Your Ref: OWQC23626
Our Ref: BE/69/19/OUT
Please ask for:
Mr S Davis

Outline planning application with all matters reserved except access for 31 No. houses and flats with car parking, landscaping and associated infrastructure & access off Shripney Road (A29), all following the demolition of the existing dwelling & outbuildings - This application is a Departure from the Development Plan
The Cottage Shripney Road Bognor Regis

Thank you for your internet comments made on 8th July 2019 which has been recorded as **'an objection'** with the comments as follows:

Proposed Access Drawing 160818-07B

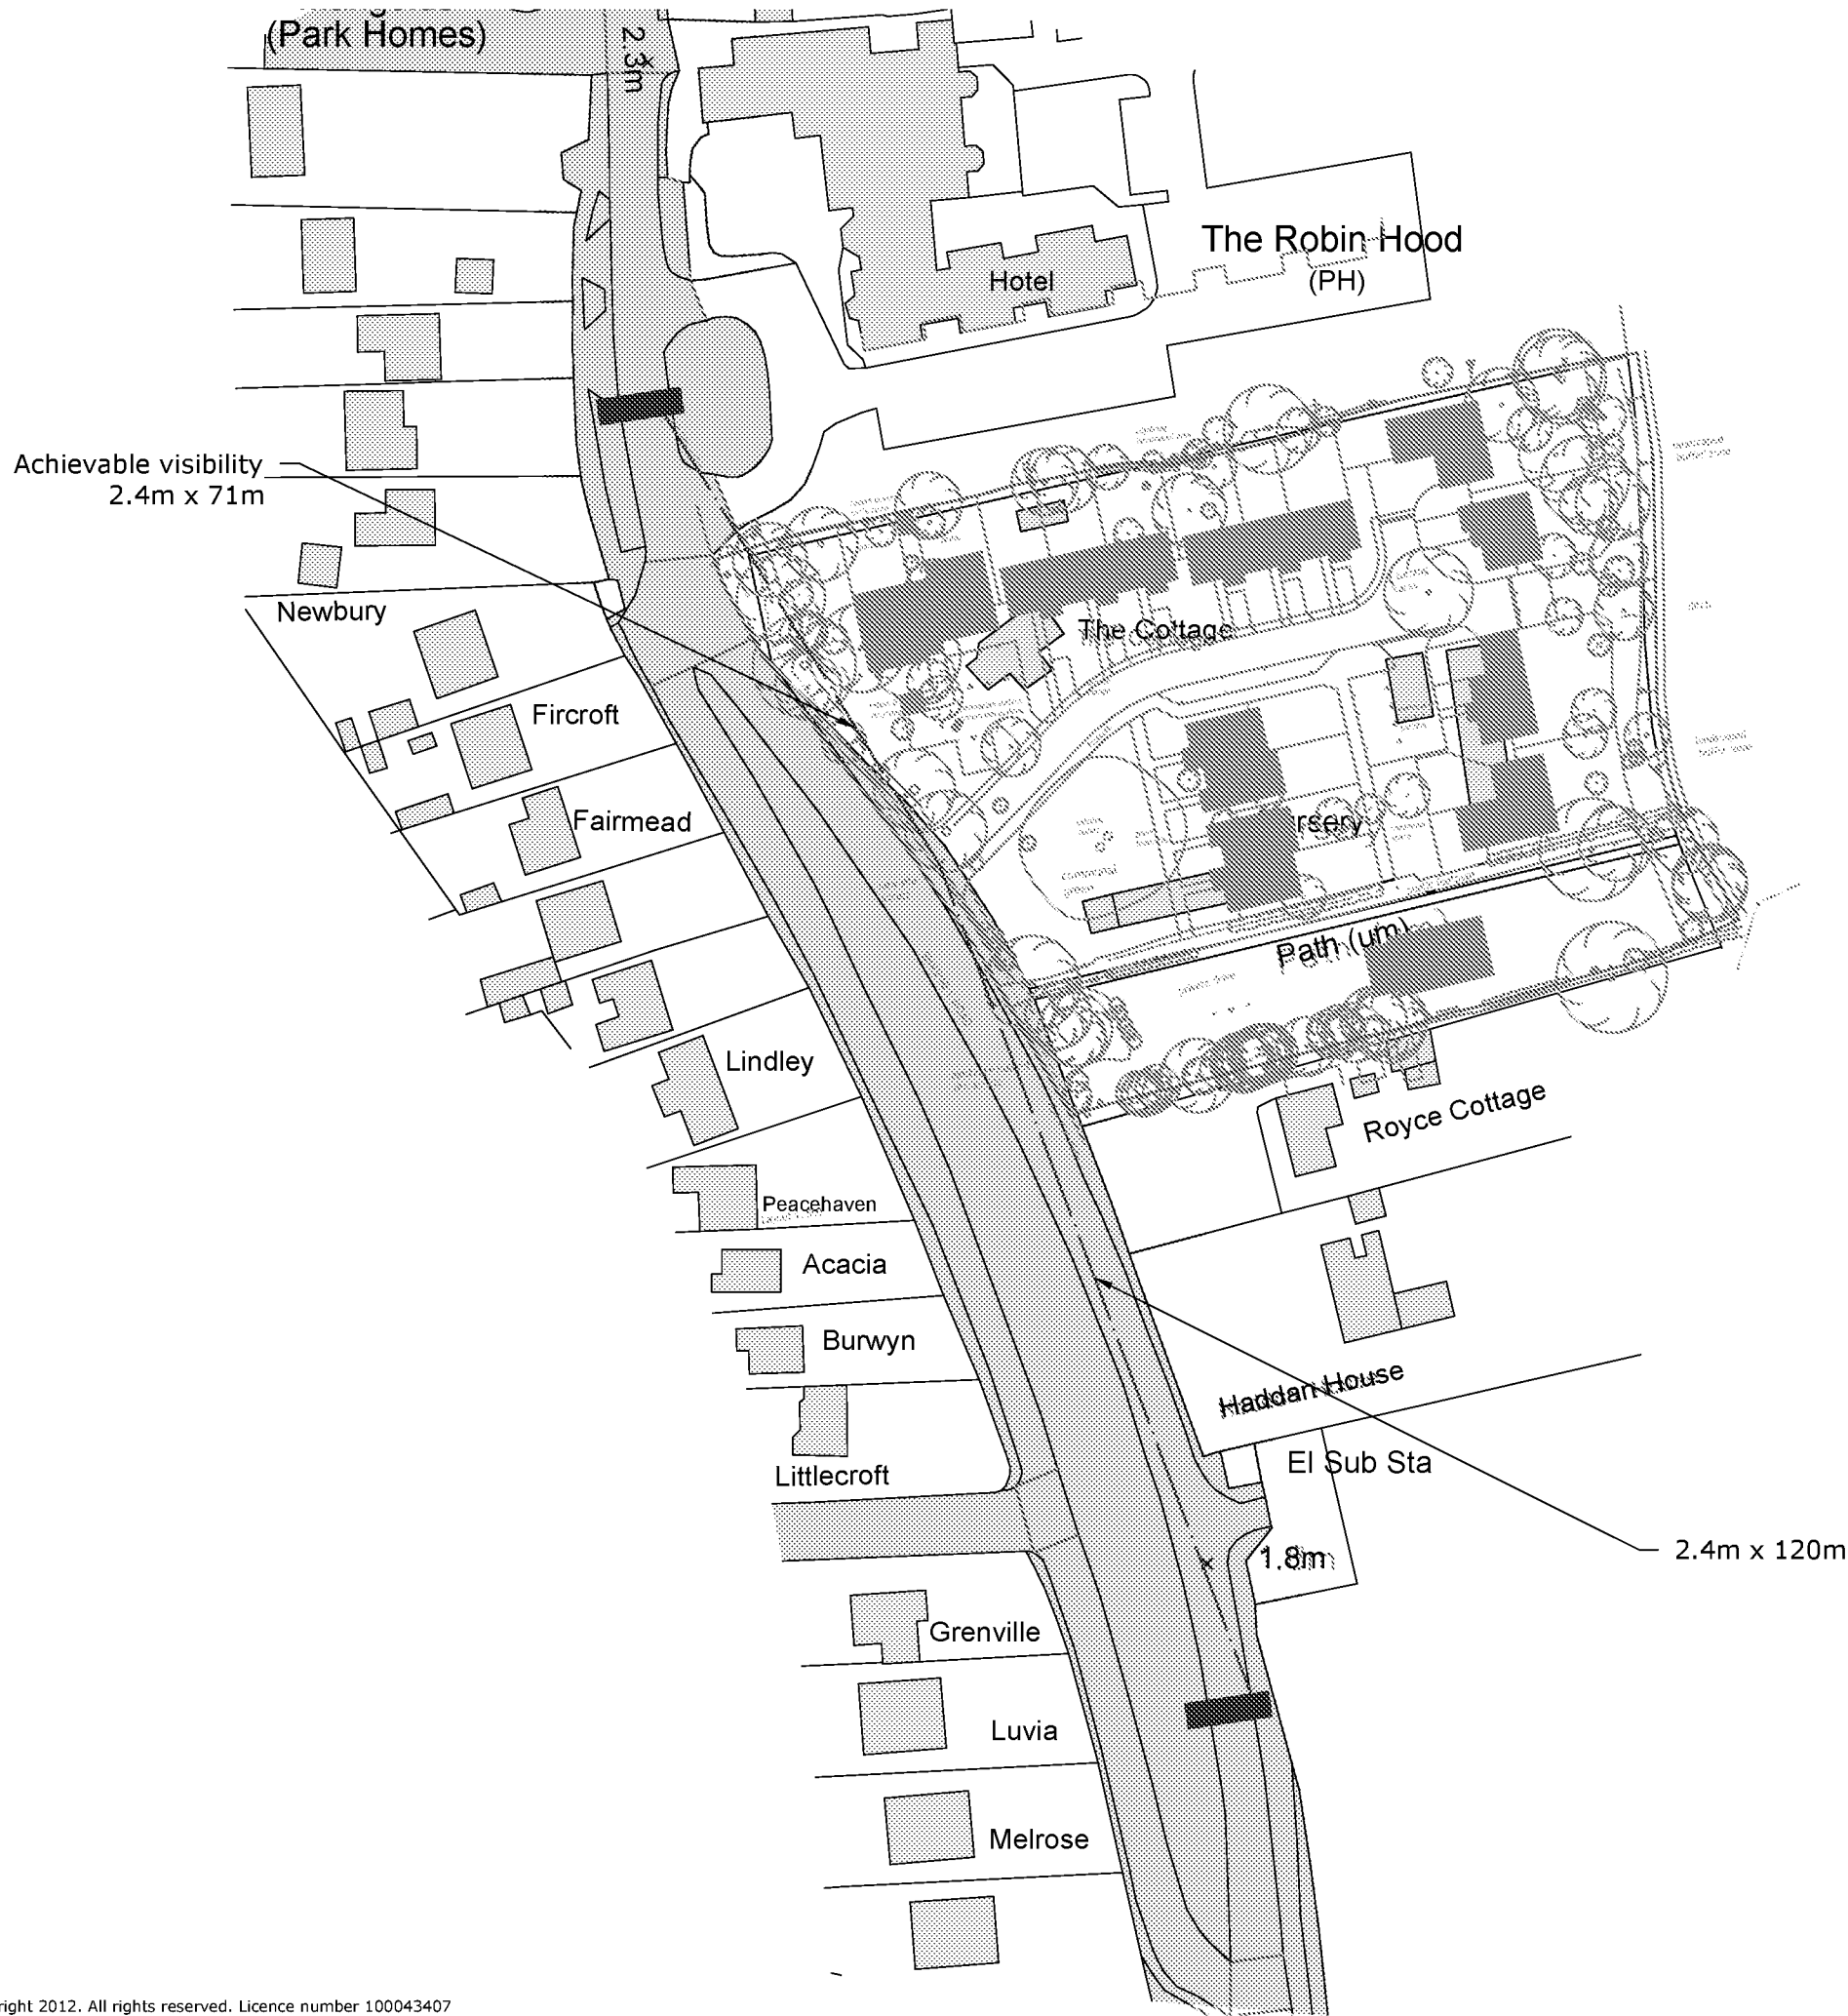
The position of the site is close to a bend which will not add to the safety of pedestrians or

cyclists using the proposed crossing between the development and the footway opposite on the A29.
